Our Ref: 10283-JW-SM-13092023

13th September 2023

Re: Proposed conversion of annexe, Marae Barn, St Germans – Structural Inspection Report

SCALES @ A1 <b>1:50 1:100</b>	DRG No.
DATE <b>AUG 20</b>	<b>3886/1B</b>
DRAWN aht design	
CHECKED

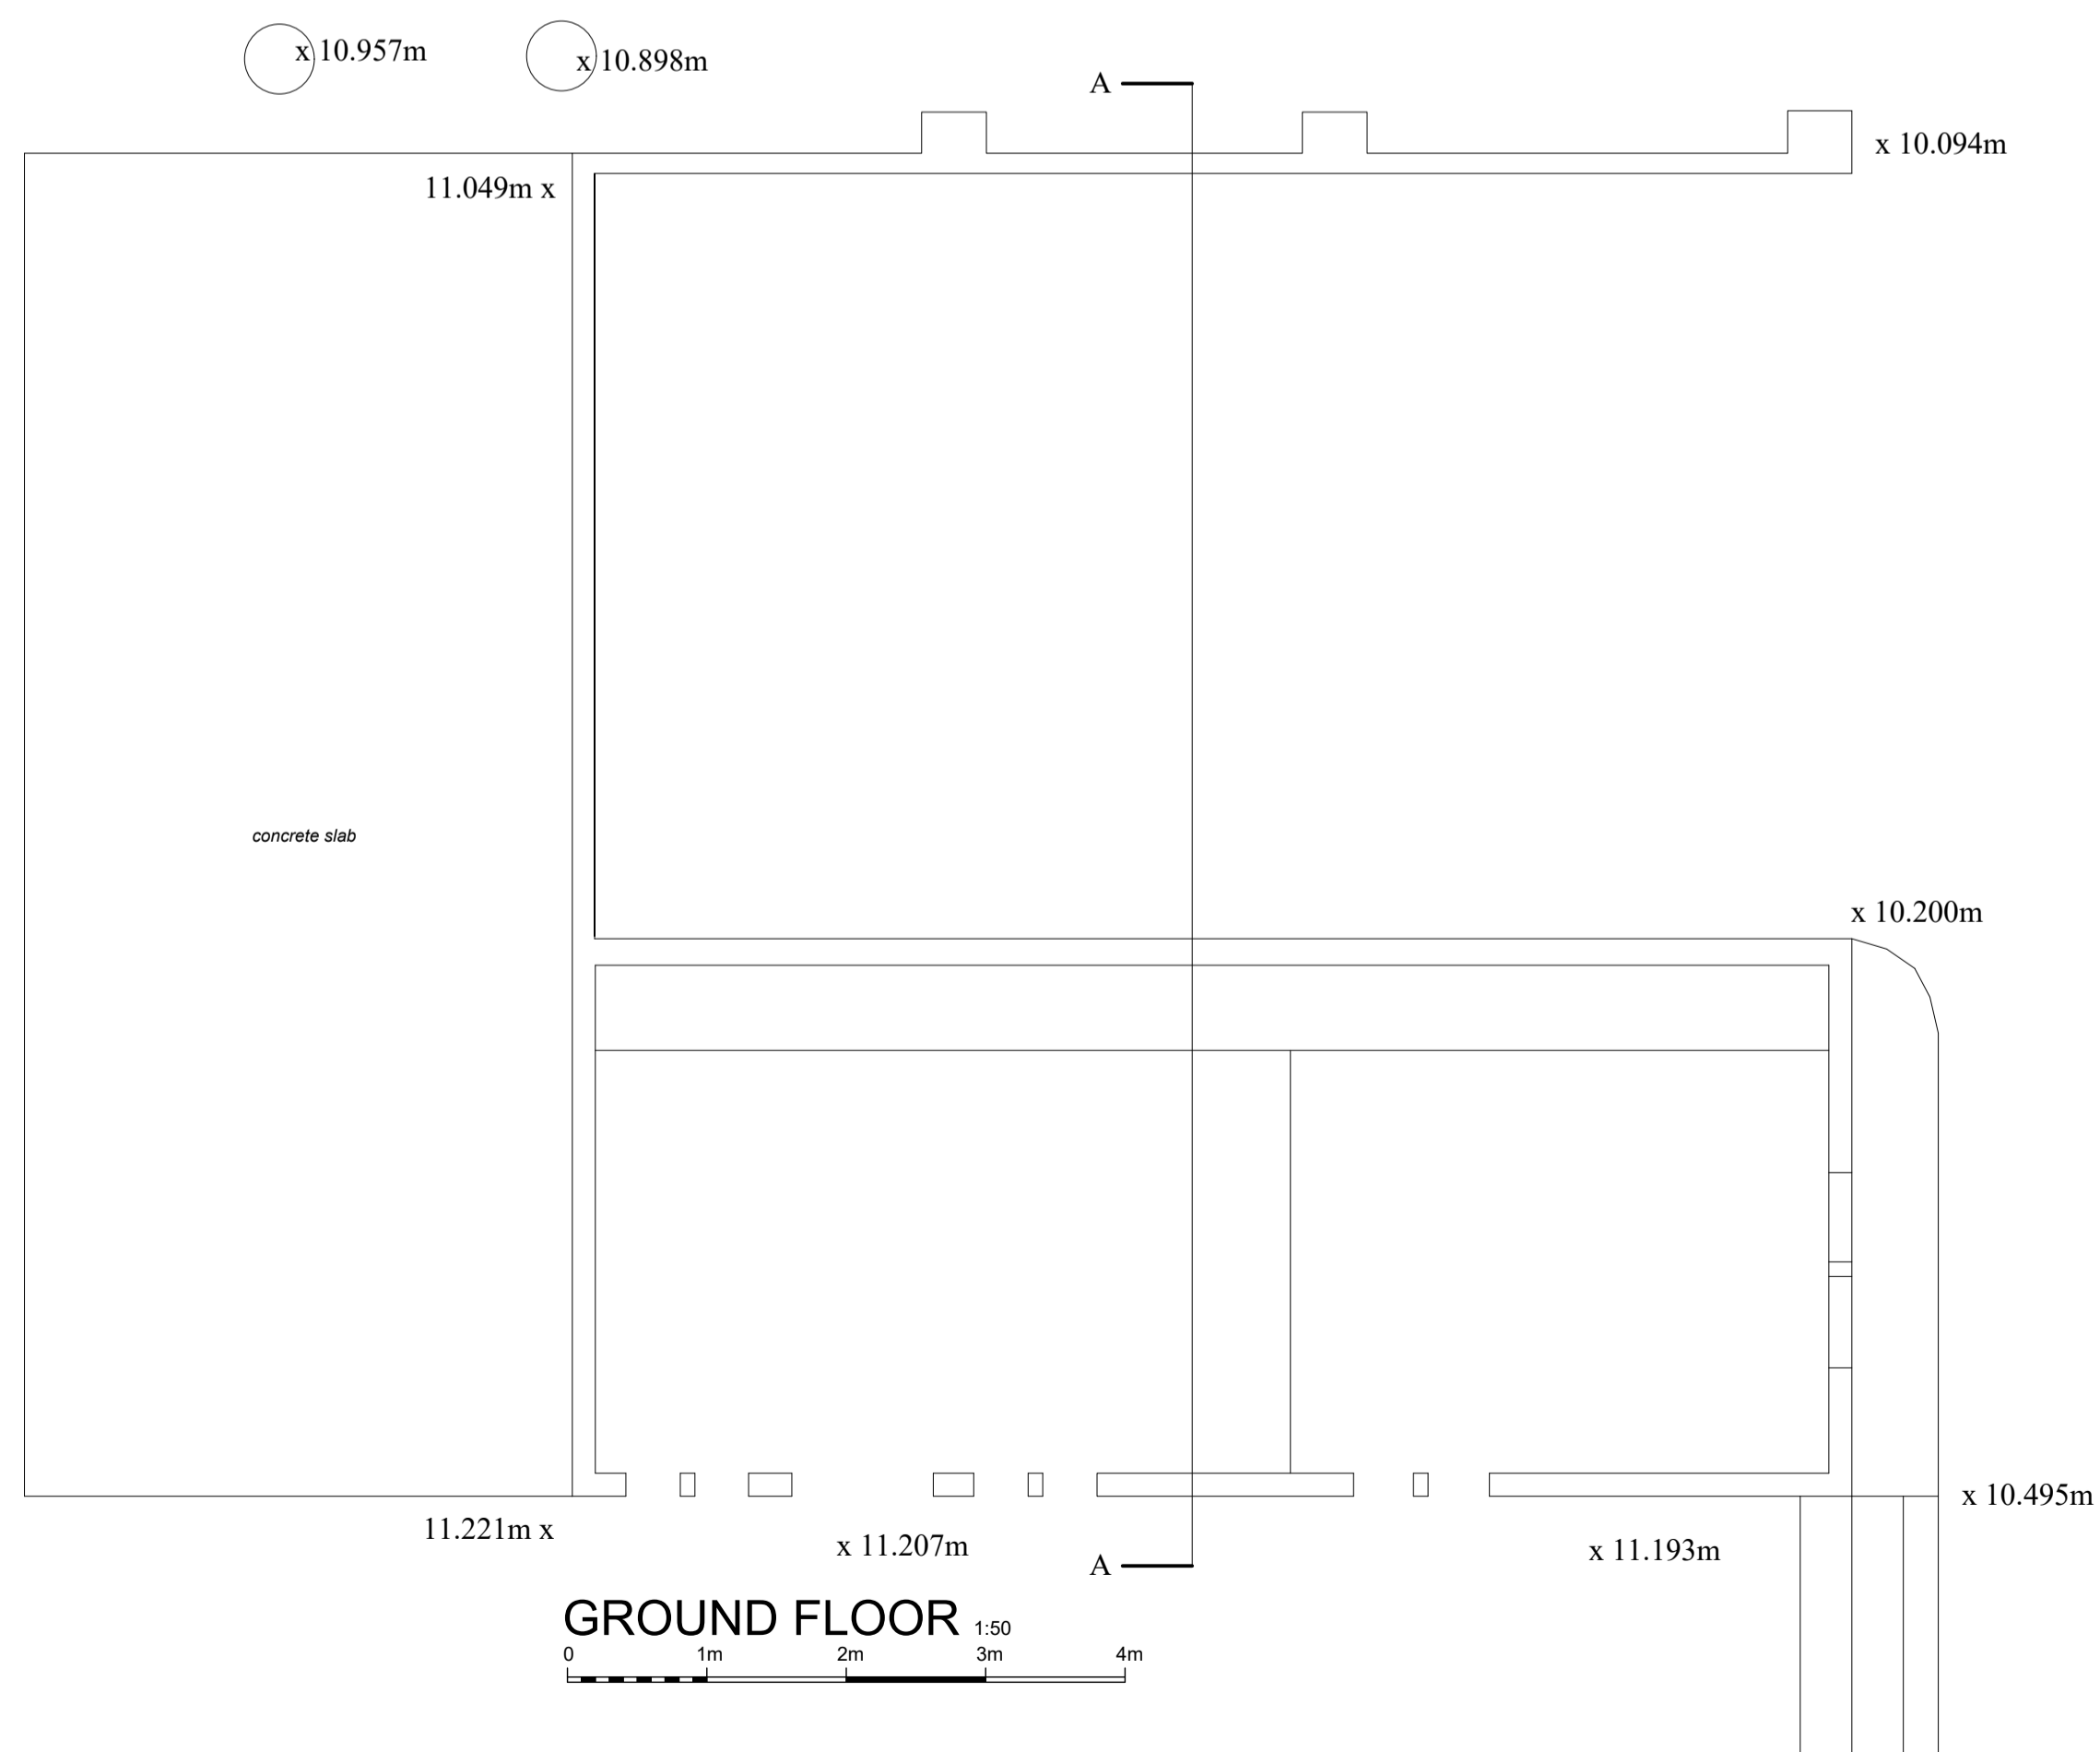
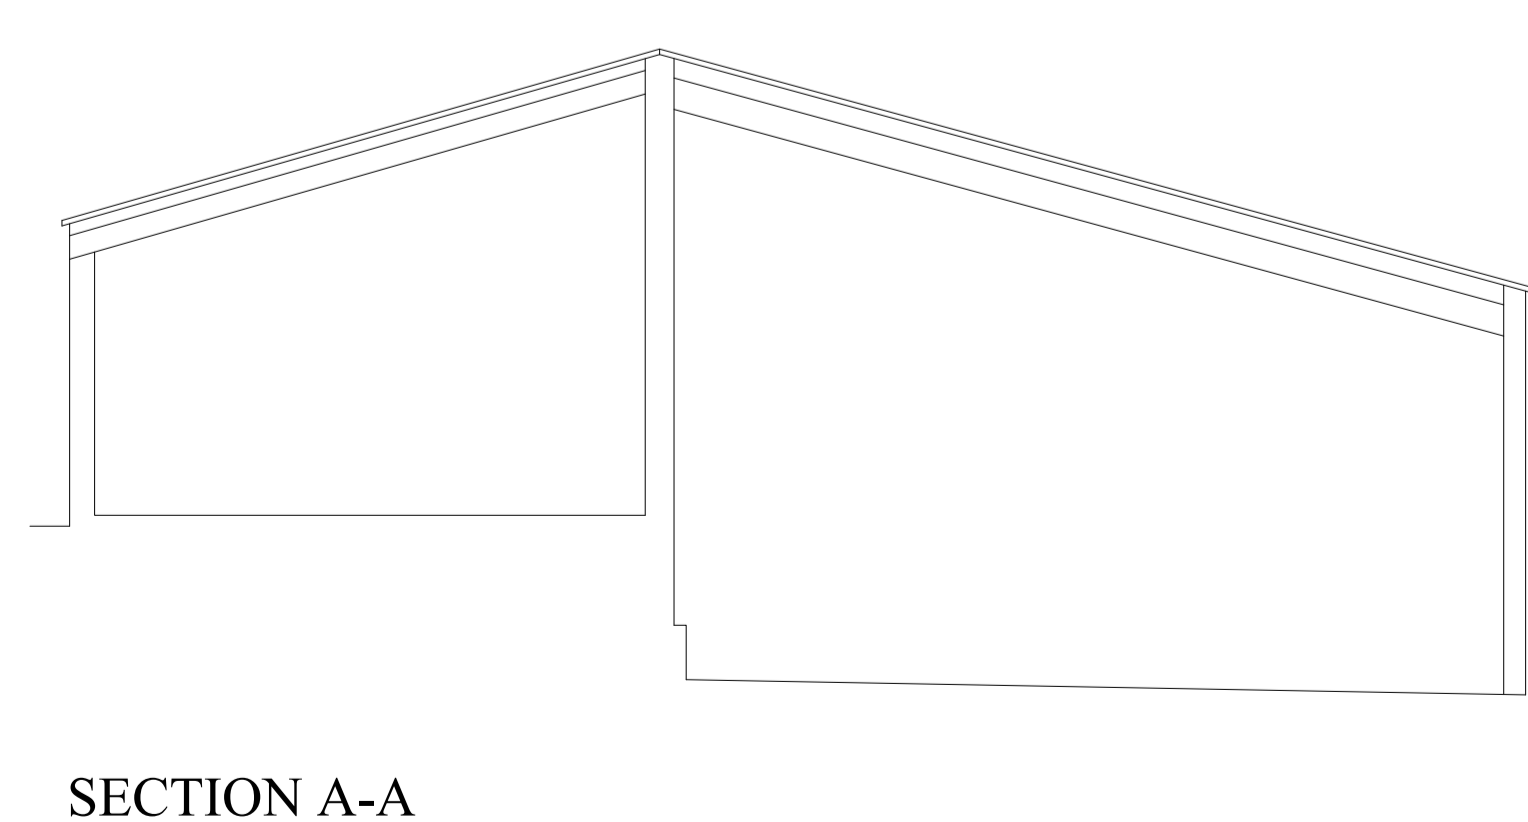
The annexe is detached, single storey but is split level (see AHT design survey drawing 3886/1) and the proposals for the conversion of the annexe are shown on AHT design drawing 3886/2.

The external walls of the annexe are typically constructed of 100mm 'single skin' concrete blockwork. Within the northern wall there are three number concrete blockwork piers 440mm square.

There is an internal partition wall formed in 100mm 'single skin' concrete blockwork between the upper and lower annexe with a concrete blockwork retaining wall at low level, which would appear to be formed in 215mm wide concrete block. The concrete foundation beneath this wall is exposed and measures approximately 300mm in depth and at the eastern end the formation beneath the wall can be seen and is a light brown clayey gravel (weathered slate) which appeared to be competent.

The retaining wall between the existing external concrete slab along the west elevation and the lower annexe would appear to be of 100mm 'single skin' concrete blockwork construction.

The roof over the annexe is pitched with a corrugated 'asbestos cement' roof covering supported on a timber roof structure. Above the lower annexe the structure comprises three number timber purlins 75mm (w) x 125mm (Dp) spanning onto three number principal rafters which are 200mm (Dp) and of various widths between 50 and 70mm. The principal rafters span from the concrete blockwork piers within the north elevation wall onto the internal concrete blockwork partition. Over the upper annexe the structure comprises three number timber purlins 75mm (w) x 100mm (Dp) spanning from the east and west external walls onto two number timber principal rafters 80mm (w) x 150mm (Dp) spanning from the south elevation wall onto the internal concrete blockwork partition.

- The ends of the timber purlins where they bear into the east wall of the lower annexe are rotten.
- b) There is a vertical crack in the west external wall of the lower annexe approximately 1.5m from the north west corner the crack measures approximately 2-3mm in width at the top and stops at ground level externally.

- c) There is vertically cracking of the north blockwork wall one crack is located centrally in the middle wall panel between piers the crack measures 2-3mm in width at the top and tapers in width towards the ground. Another vertical crack is located in the wall panel between the piers at the eastern end of the wall and is similar in width to the crack in the middle panel.

- d) Beneath the vertical crack in c) above at the eastern end there is an area of blockwork just above ground level which is eroded.
- e) There is a vertical crack located approximately centrally in the internal blockwork partition between the upper and lower annexe. The crack measures approximately 2-3mm in width at the top and stops at the upper floor slab and cannot be seen in the retaining wall below the wall from within the lower annexe.

- i) At the right hand side of the door into the upper annexe there is a pier of blockwork that is cracked at high level where the principal timber rafter which is rotting bears into the wall.

- a) The roof structure above both the lower and upper annexe are in very poor condition and should be replaced.
- b) The 100mm blockwork of the west wall above the lower annexe is cracked and the retaining wall beneath this wall with the lower annexe appears possibly to be of 100mm constructed. We would recommend that this wall is taken down and a new retaining wall / wall constructed. The reconstructed retaining wall will also support the new extension.

- c) The 100mm blockwork between the piers in the north elevation is cracked and eroded at low level. We would recommend that this blockwork is taken down replaced with new 'tooth and bonding' to the existing piers. The foundation beneath the piers should be checked to ensure that they are adequately founded.

- d) New concrete ground bearing slabs will be required. The details between the retaining wall foundation supporting the upper annexe and the lower annexe floor will require consideration to ensure the foundation is not undermined.

- e) The vertical crack in the blockwork partition wall between the upper and lower annexe we would recommend is stitched using stainless steel Heli bar or equivalent.
- f) We would recommend that internal timber frame drylining is provided sheathed with plywood or 'OSB' and tied to external 100mm blockwork to provide stability to the external wall.
- g) Trial pits should be excavated to ensure that the walls of the upper annexe are adequately founded.
